Architecture and Landscape Section 4.55 Modification  
Port Macquarie Campus

Project	Hastings Secondary College	Code	HSPM
Organisation	FJMT	Revision	1
To	Bill Rushworth	Date	14/04/2022
		Doc Number	A-000055

title
General Arrangement Plans
General Arrangement Plan - School Entry Canopy Plan

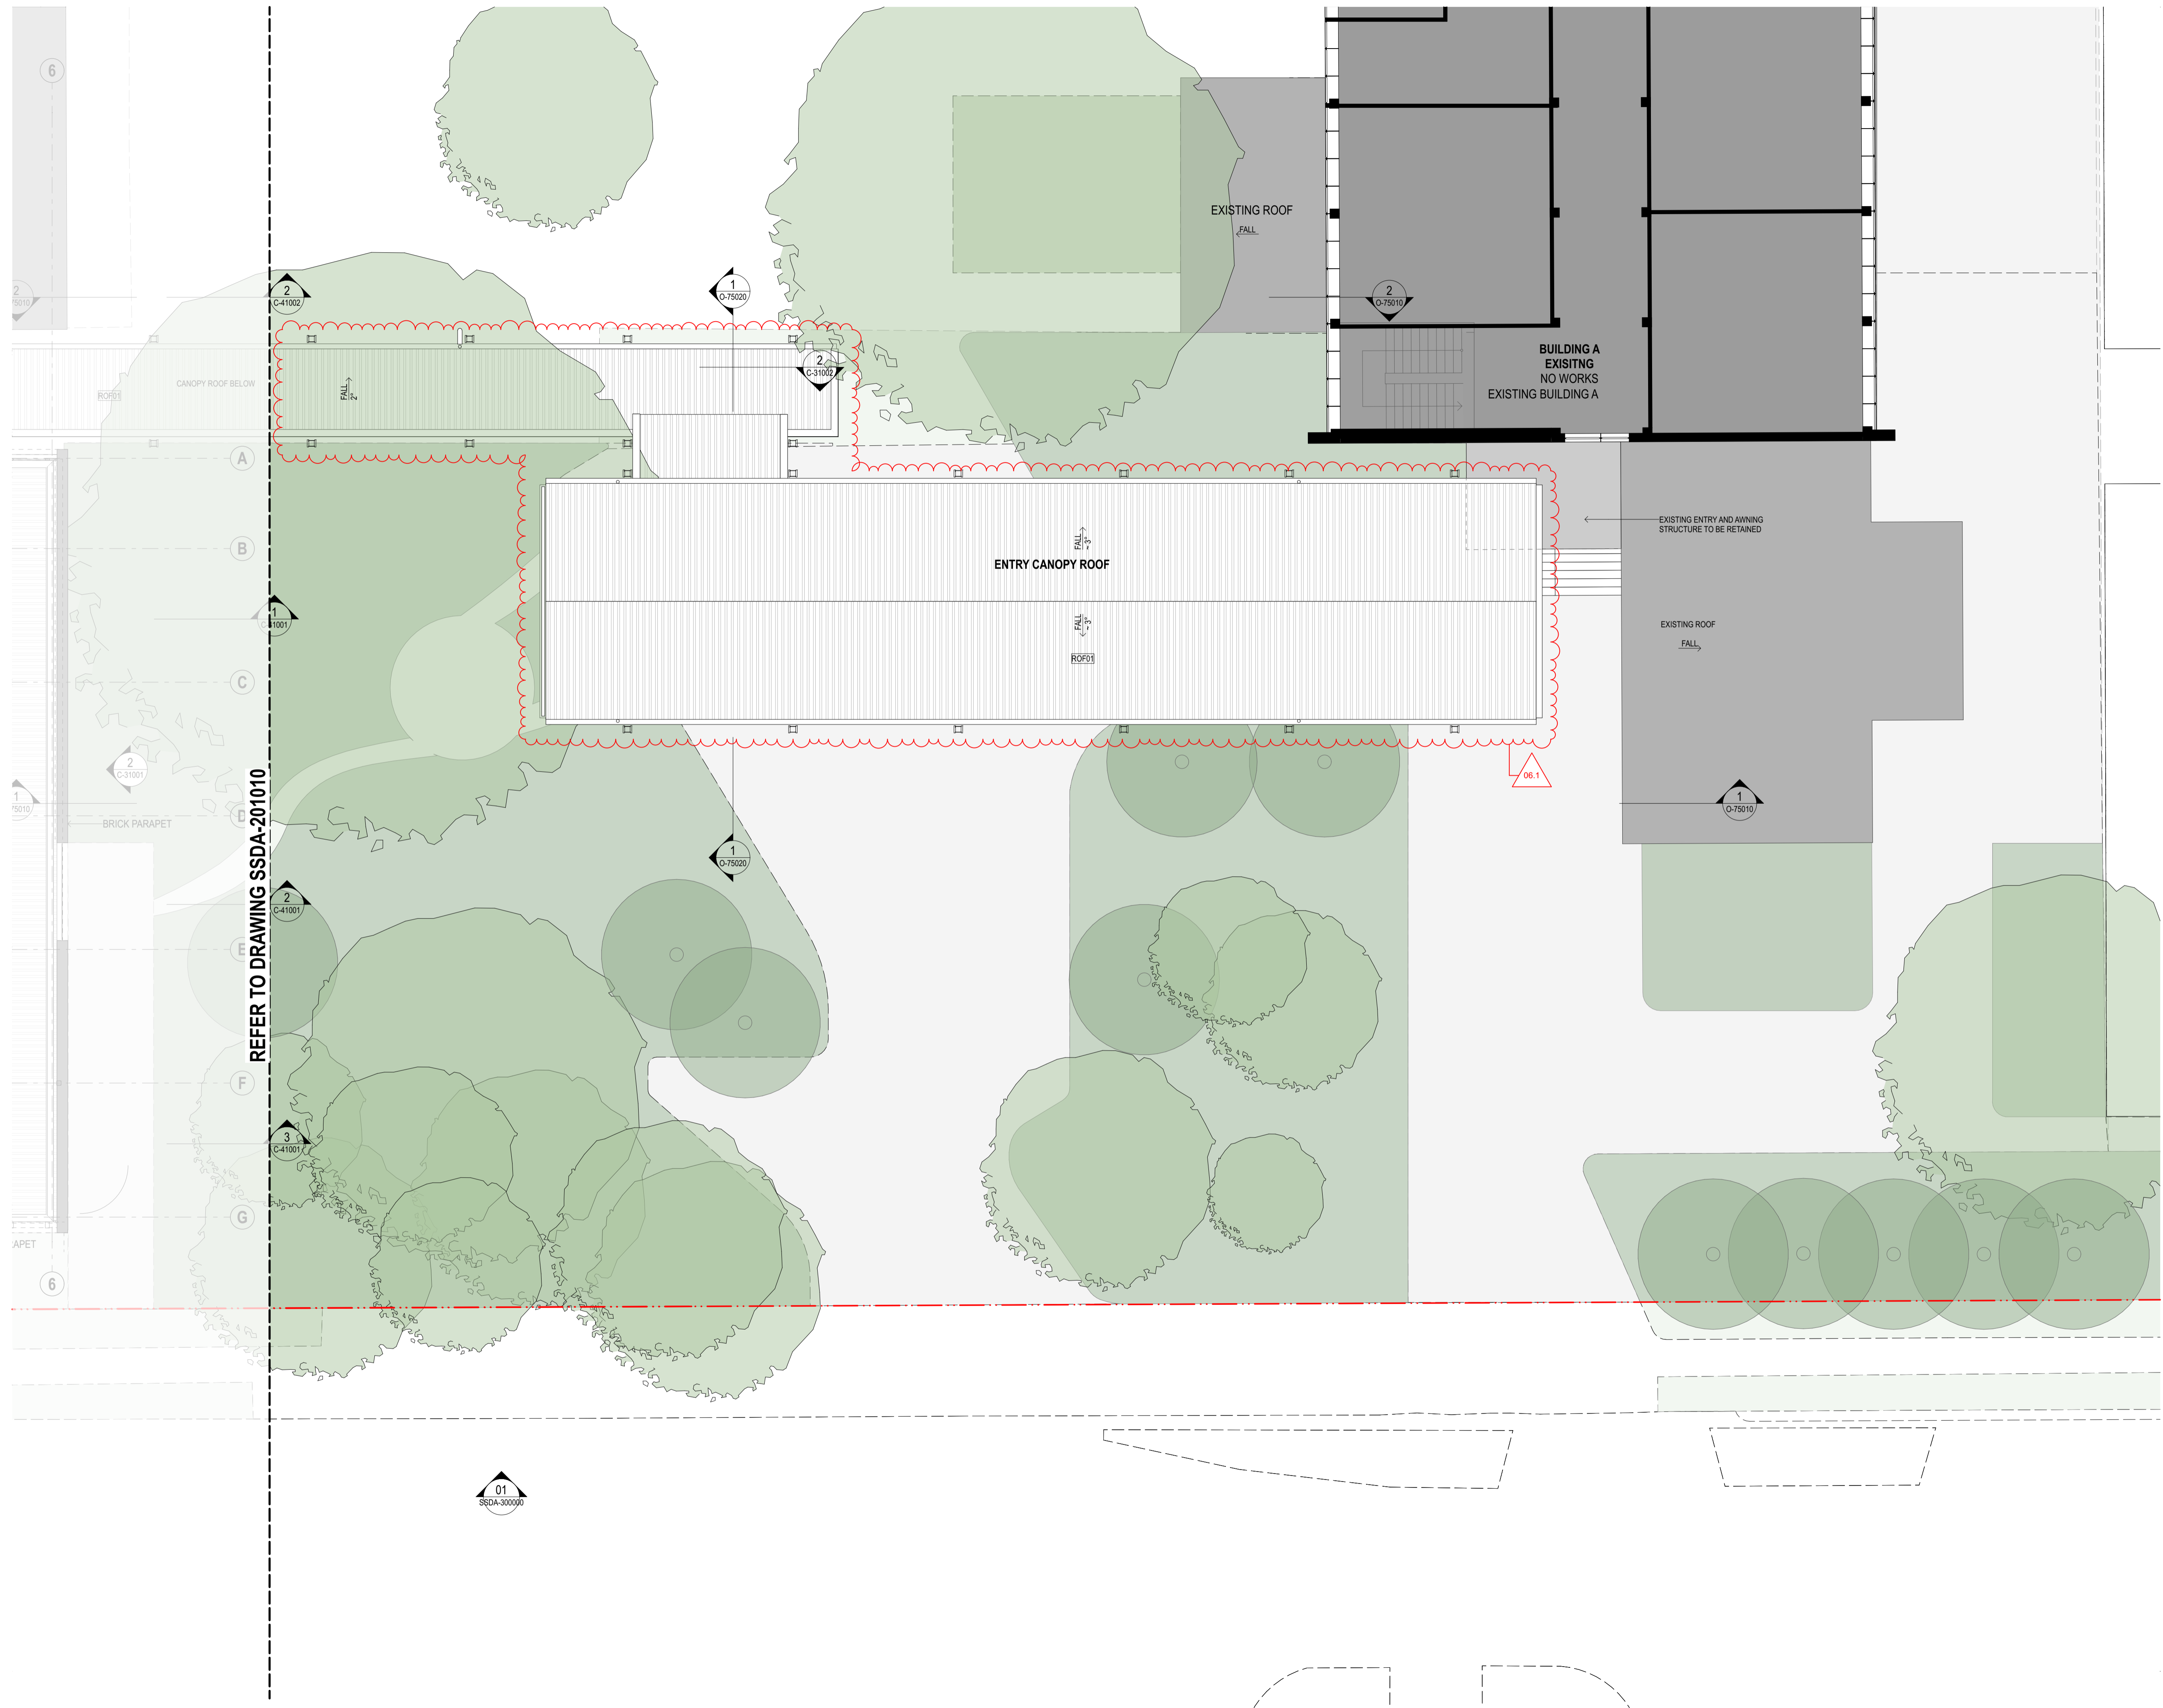
6.2	Minor adjustment to lift and associated walkway to meet build ability requirements.
			6.3	Minor adjustment to lift and associated walkway to meet build ability requirements.
SSDA 201070	05	General Arrangement Plan - School Entry Canopy Plan	5.1	Revision to entrance sequence including the reinstatement of the existing entry stairs and relocation of ramp to provide a more equitable response.

5.2	Revision to entrance sequence including a relocated ramp and reinstatement of stairs to provide a more equitable experience.
SSDA 201071	06	General Arrangement Plan - School Entry Canopy Roof Plan	6.1	Revision to entrance to provide a simpler canopy and a more equitable response to the Main Entrance. The canopy is held back from the existing porch roof which is maintained.
280000 GFA Plans				
SSDA-280000	06	GFA Plans	6.1	Existing access/egress stairs and adjacent entrance and stores converted to an external zone to enable the consolidation of Building B and CAPA. Transfer of FECA to UCA.

title
Area Calculation Plans
GFA Plans & Area Schedule

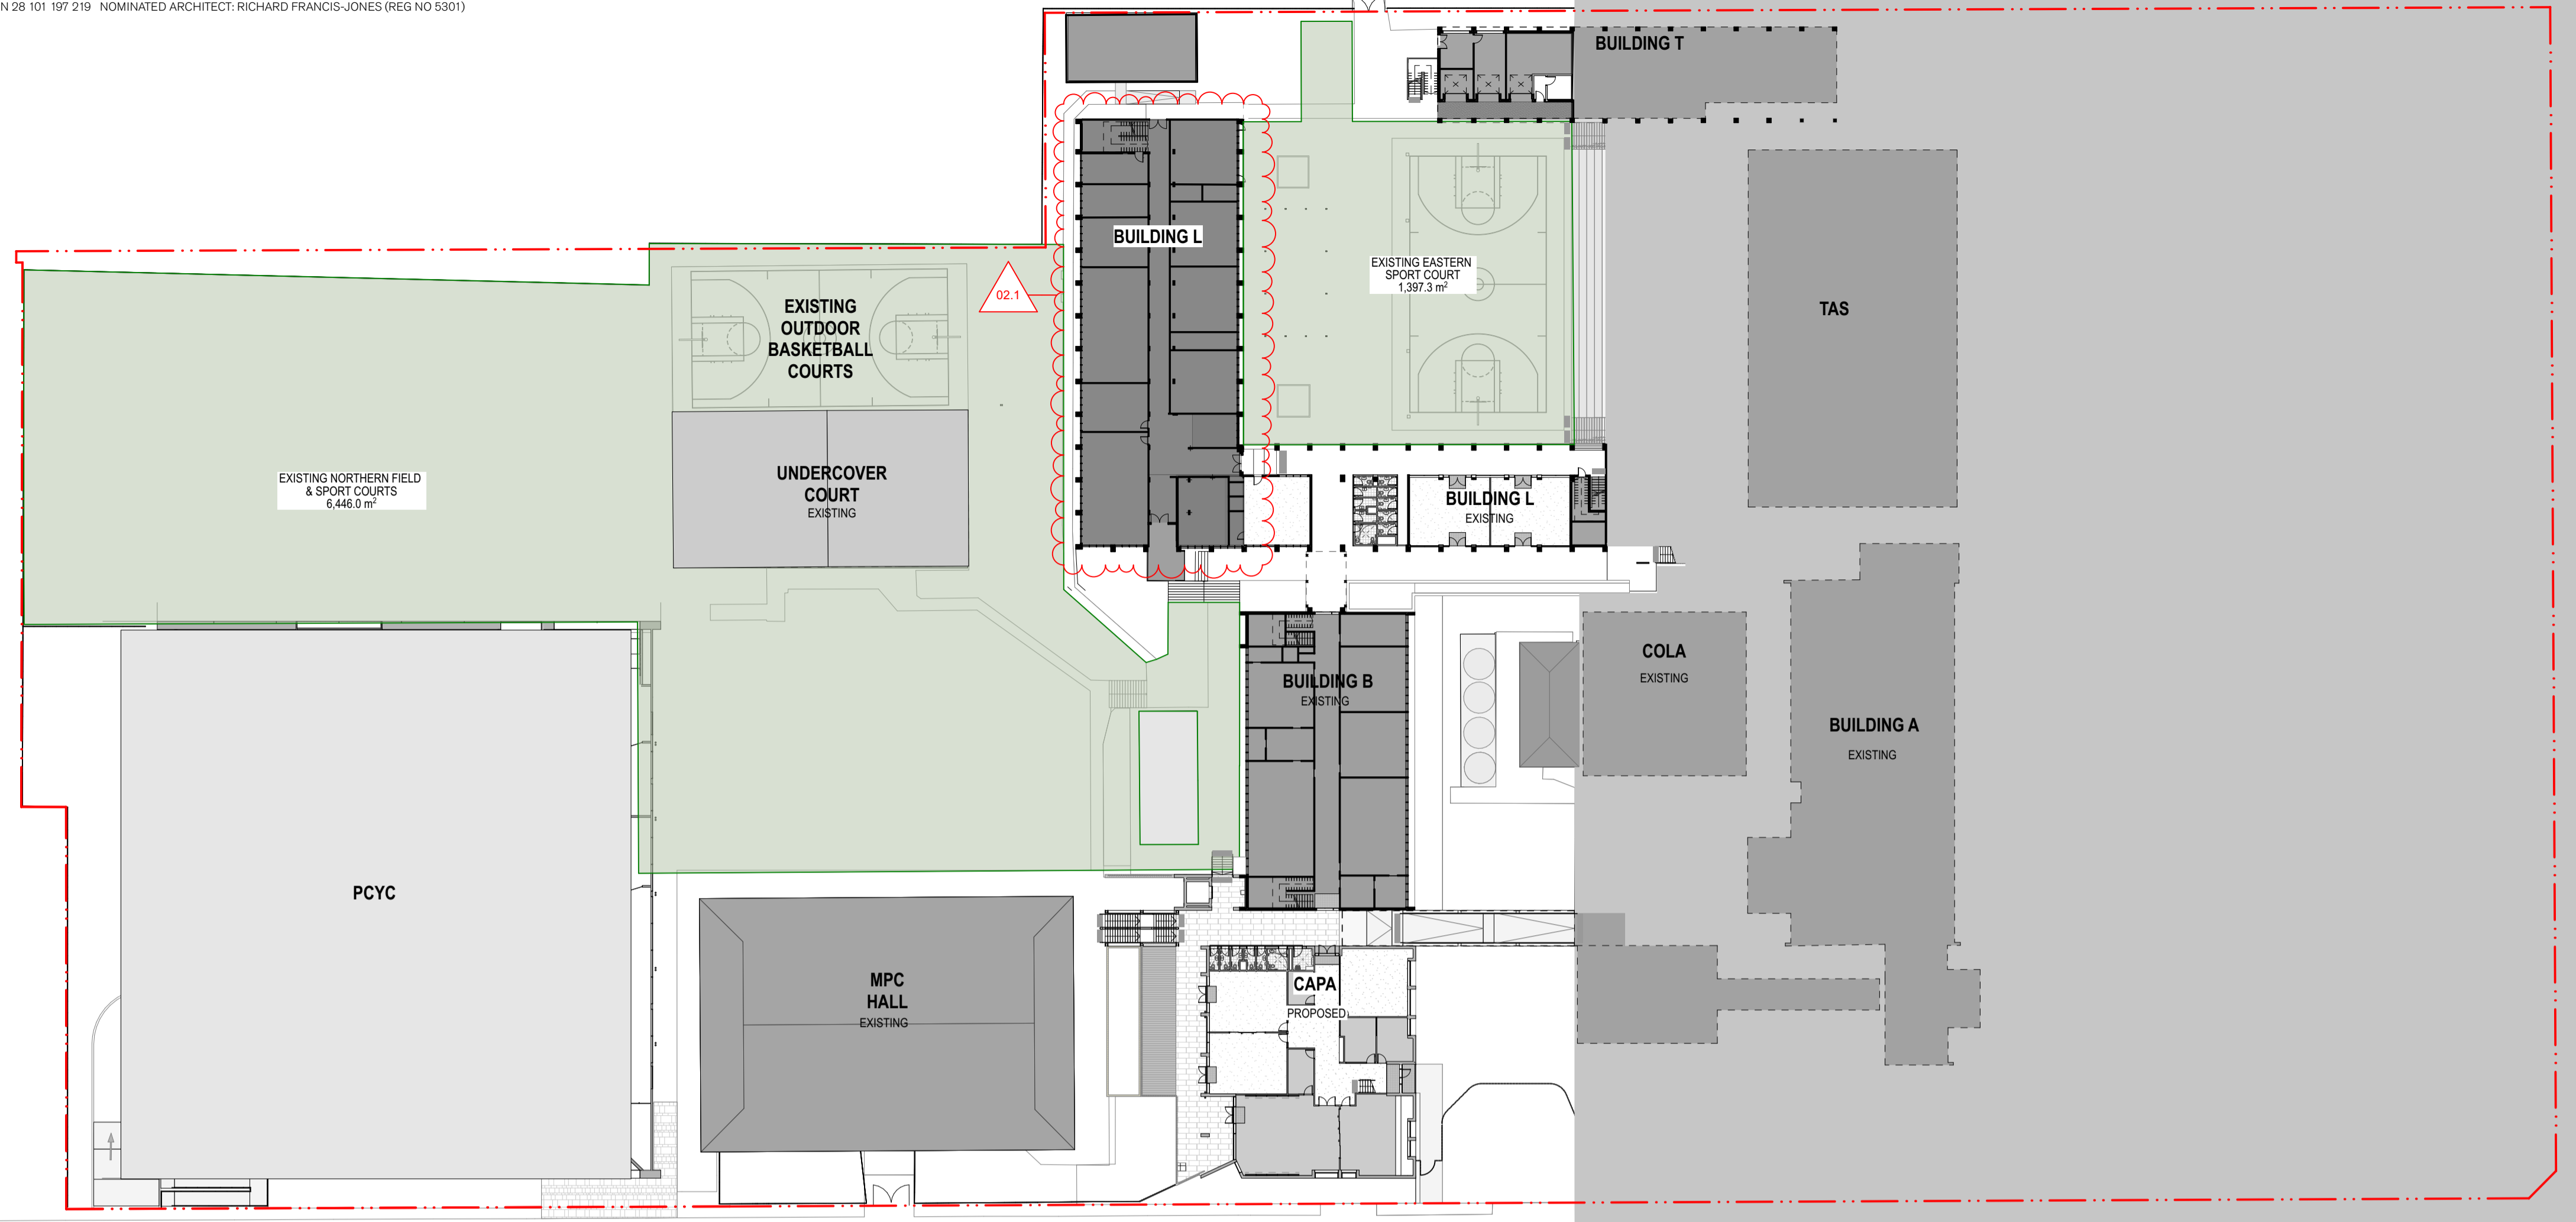
6.2	Relocation of Supported Learning to provide a better connectivity with adjacent departments. No work to this zone.
SSDA -280001	09	GFA Area Schedule	9.1	Relocation of Supported Learning (previously in Ground Level Building L) to provide a better connectivity with adjacent departments.

9.2	Area schedule updated to reflect changes to canopy
			9.3	GFA Schedule updated to reflect changes. Note - majority of changes are redefinition of areas rather than new area.
SSDA-280100	02	Outdoor Recreation Area	2.1	Updated layouts between Building L and B captured. No changes to proposed areas.
SSDA-280201	02	UFA Plans	2.1	Relocation of Supported Learning (previously in Ground Level Building L) to provide a better connectivity with adjacent departments.
300000 1:200 Elevations				
SSDA 300000	05	Elevations - West and South	5.1	Further co ordination and resolution of external plant.
